## **Tees CCPP Project**

### **The Tees Combined Cycle Power Plant Project**

### **Applicant's Response to the Examining Authority's Information Requests**

### **Examination Deadline 7**

**Figure E3.1** *Modelled NO<sub>x</sub> Concentrations*

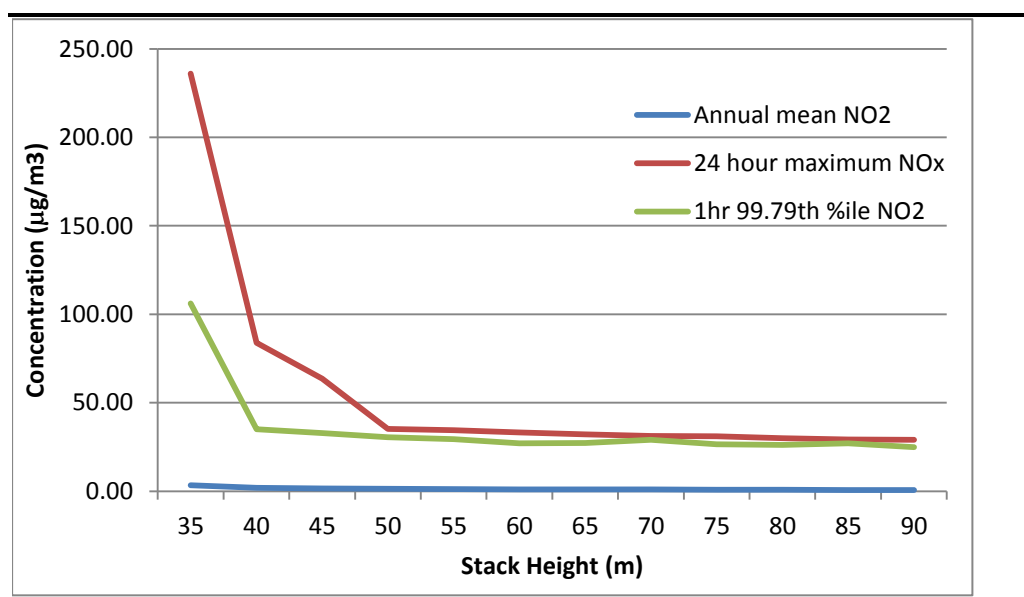
NO.	TOPIC	EXA'S REQUEST	APPLICANT'S RESPONSE
		<p>assessed in the ES (in relation to the height and diameter of the stack/s). The proposed new requirement also fails to acknowledge the necessary relationship between what is assessed and examined and what can be authorised.</p> <p>The Applicant is therefore asked to:</p> <ul style="list-style-type: none"> <li>Consider further drafting changes to the DCO in order to fix the stack height and diameter so that it aligns with what has been assessed (for example by amendments to the description of the authorised development in Schedule 1) and to comment on the above points, with reference to the relevant case law as necessary.</li> <li>In relation to requirement 4 (1) (d) and (2) (b), the LPA is asked to comment on whether or not (in its view) it would have jurisdiction to entertain a subsequent application to approve a stack height of less than 75 metres.</li> </ul>	<p>different environmental effects to those already identified in the Environmental Statement.</p> <ul style="list-style-type: none"> <li>The wording in requirement 4(4) has been deleted.</li> </ul> <p>An updated draft DCO (track changed version – Application Document Ref: 8.63) has been submitted as part of the Applicant's Deadline 7 submission.</p> <p>The Applicant considers that the proposed wording appropriately constrains the ability to alter the stack height and would not allow the relevant planning authority to authorise a change which is beyond the remit of what has been assessed in the submitted EIA. This type of wording for a requirement, i.e. to allow a small degree of flexibility, has been accepted in many approved DCOs to date.</p> <p>The Applicant is aware of the inappropriate use of open ended tailpiece conditions (which applies equally to requirement in DCOs) as referred to in the cases listed. We do not consider that the proposed wording falls foul of the 'Midcounties principle'. It is not an open ended requirement to change the stack height and appropriately restricts the basis upon which any change in stack height can be permitted by the relevant planning authority in consultation with the Environment Agency.</p> <p>The Applicant would like to retain some flexibility in stack height pending the final decision on a technology provider, in particular in case there is an opportunity to reduce the stack height further below 75m to address representations made by the local community with regards to the potential visual effects of the Proposed Development.</p>

Figure 1 - Tees CCPP High Level Layout

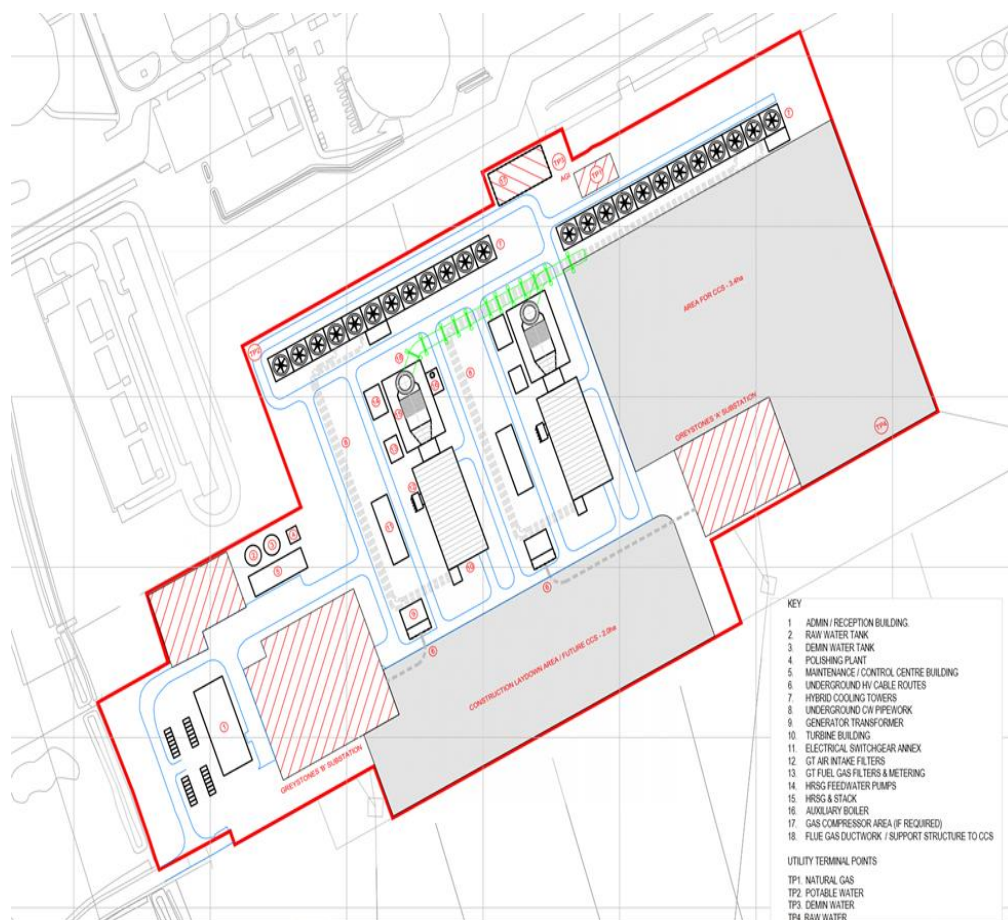
3	DCO Requirement 13(2)(a)(ii) – noise monitoring specification within the Construction Environmental Management Plan ("CEMP")	<p>With reference to the Applicant's Deadline 5 response to the ExA's second written questions, specifically Question 2.6.1 [REP5-005], the Applicant is requested to:</p> <ul style="list-style-type: none"> <li>amend the drafting of dDCO Requirement 13 (2)(a)(ii) and the draft CEMP [REP6-009] to include specific reference to the two types of construction noise monitoring detailed in the answer to the question.</li> </ul>	<p>The Applicant has updated the documents to refer to the stated guidance.</p> <p>The Applicant has submitted an updated draft CEMP (Application Document Ref: 6.3.20) and updated draft DCO as part of the Deadline 7 submission (Application Document Ref: 8.63).</p>
4	Carbon Capture Readiness Report ('CCR Report')	<p>The Applicant indicated [Q2.0.2, REP5-005] that it would provide a further CCR report/statement at Deadline 6, but to date has not submitted this information. The ExA notes the comments from the Environment Agency (EA) in [AS-028]. Can the Applicant confirm precisely when it intends to submit the required information to the Examination, noting that the EA has advised it will take approximately three weeks for them to review and provide their comments?</p>	<p>The Applicant has provided further information to address the comments made in the letter from the Environment Agency dated 13 September 2018 (Ref: NA/2018/114039/08-L01). The further information covers the following matters:</p> <ul style="list-style-type: none"> <li>Power Output Capacity;</li> <li>Annex C from the Department of Energy and Climate Change guidance entitled "Carbon Capture Readiness (CCR) A guidance note for section 36 Electricity Act 1986 consent applications", as follows: <ul style="list-style-type: none"> <li>C2 – Power Plant Location;</li> <li>C4 – Gas Turbine Operation and Increased Exhaust Pressure;</li> <li>C6 – Steam Cycle;</li> <li>C8 – Compressed Air System;</li> <li>C9 – Raw Water Pre-treatment Plant;</li> <li>C10 – Demineralisation Plant;</li> <li>C11 – Waste Water Treatment Plant; and</li> <li>C12 – Electrical.</li> </ul> </li> </ul> <p>The further information provided to the Environment Agency is set out in a memo prepared by AECOM. The memo (Application Document Ref: 8.64) forms part of the Applicant's Deadline 7 submission. The Environment Agency has since issued a letter dated 21 September 2018 (Ref: NA/2018/114039/09-L01) confirming, in summary, that:</p> <ul style="list-style-type: none"> <li>The Applicant has provided sufficient information to address the Annex C checklist.</li> <li>There are no foreseeable barriers to the technical feasibility of carbon capture plant retrofit for a</li> </ul>

NO.	TOPIC	EXA'S REQUEST	APPLICANT'S RESPONSE
			<p>1,520MW CCGT.</p> <ul style="list-style-type: none"> <li>The Applicant will need to provide further evidence to demonstrate the feasibility of a power plant with a maximum capacity of 1,700MW.</li> </ul> <p>The Environment Agency has therefore proposed a requirement that places a limit on electrical output until such a time that further information is provided to demonstrate that 1,700MW is feasible. The proposed text is set out in the letter dated 21 September 2018 (Ref: NA/2018/114039/09-L01).</p> <p>The Applicant agrees with the principle of using such a requirement, as set out in the letter to the ExA dated 06 September 2018 (Application Document Ref: 8.49). However, the Applicant has proposed a minor amendment to the wording proposed by the Environment Agency, on the basis that it is not possible to attach an informative to a DCO and to ensure consistency with terminology used in the draft DCO.</p> <p>The Applicant's proposed requirement text is as follows:</p> <p><i>“(1) The authorised development must not be operated to generate a net electrical output of more than 1520MWe unless and until sub-paragraph (2) has been satisfied.</i></p> <p><i>(2) The authorised development must not be operated at a net electrical output of more than 1520MWe and up to 1700MWe until the undertaker submits a scheme to demonstrate there is sufficient space within the order limits to comply with the land footprint requirement for the retrofitting of appropriate capture equipment for a generating station with a net electrical output of up to 1700MWe. The scheme shall be submitted to and approved in writing by the relevant planning authority in consultation with the Environment Agency. The scheme shall include as a minimum:</i></p> <p><i>(a) information required by the form “Environment Agency verification of CCS Readiness New Natural Gas Combined Cycle Power Station Using Post-Combustion Solvent Scrubbing,” as outlined in Annex C of the DECC Guidance for a generating station with a net electrical output of more than 1520MWe and up to 1,700MWe; and</i></p> <p><i>(b) details demonstrating how the capture equipment will fit into the space allocated for the plant including the submission of engineering design details.”</i></p> <p>The above has been added as Requirement 29 of the draft DCO. An updated draft DCO (track changed version – Application Document Ref: 8.63) has been submitted as part of the Applicant's Deadline 7 submission.</p> <p>The Applicant is currently seeking agreement with the Environment Agency on the final wording of the proposed requirement and of an agreed position on CCR. It is proposed to submit an agreed and signed Statement of Common Ground with the Environment Agency on or before Deadline 8 – with no matters outstanding.</p>
